From: Andrew Wood
Sent: 16 January 2019 16:14
To: Planning.Responses
Subject: FW: FP/188/18/HH - 68 Limmer Lane - Extension of Time Request
Attachments: 68 Limer Lane New Elevations 3 Revised.PDF

FP/188/18/HH - 68 Limmer Lane - Extension of Time Request

Drawing 3 / 4

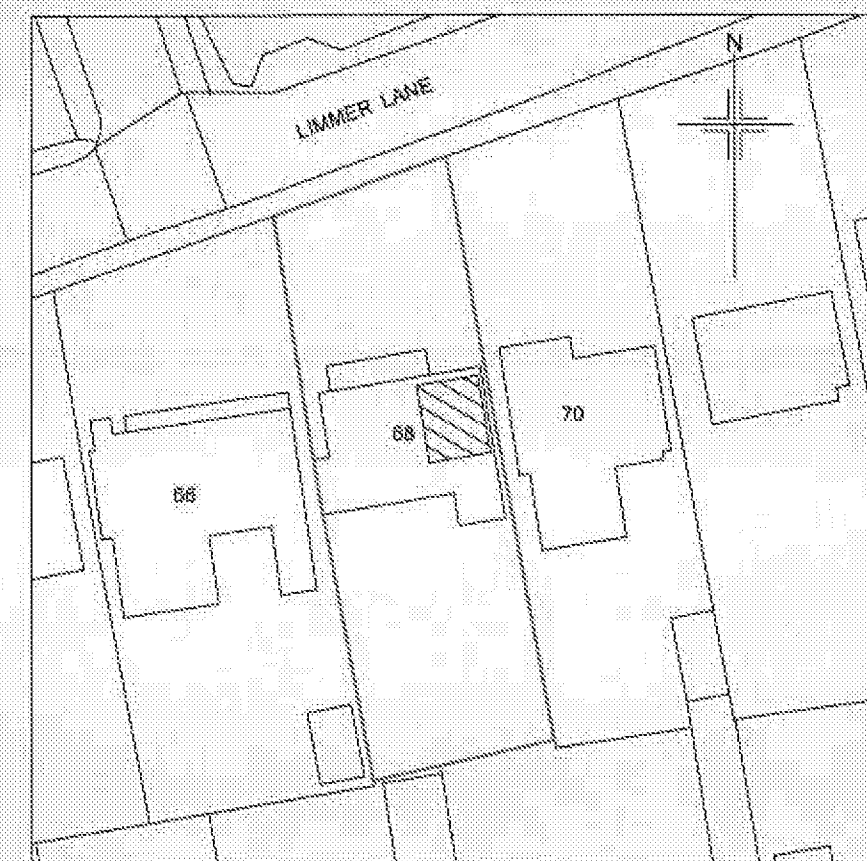
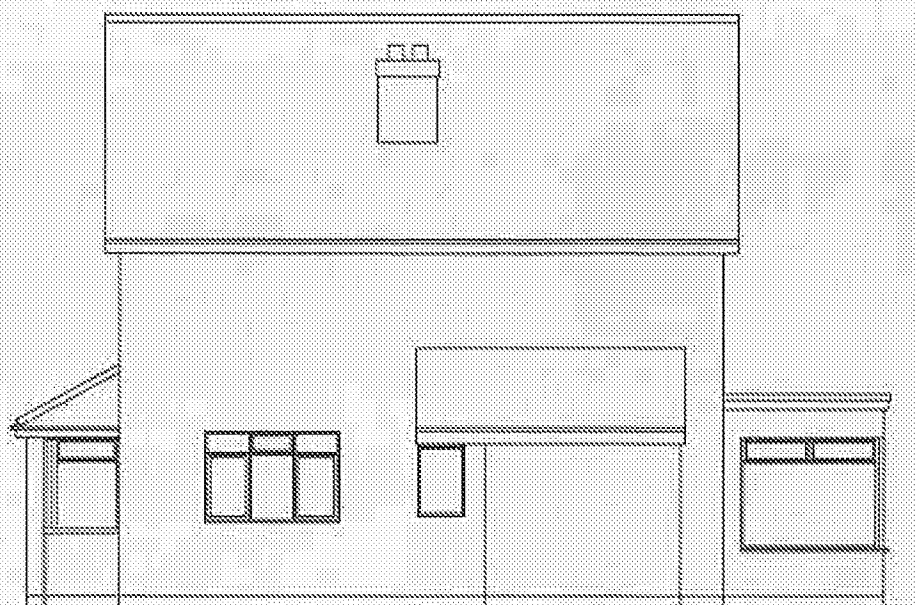
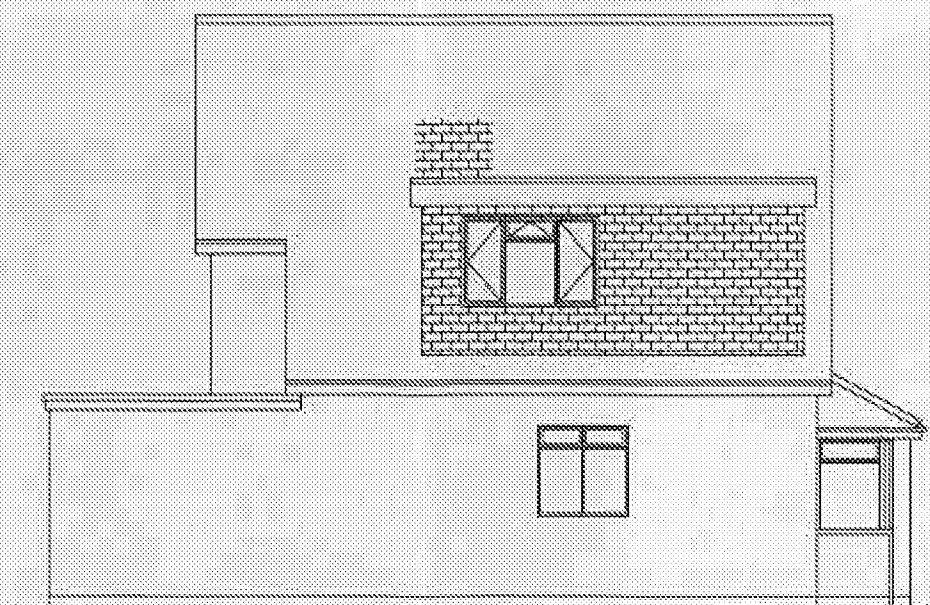
I agree to the extension of time to the 1st of February 2019 and attach revised new elevation plan replacing the tiles with half timber and plaster to the dormer to match the front gable.

I look forward to seeing your draft revised plans for the proposed dormer.
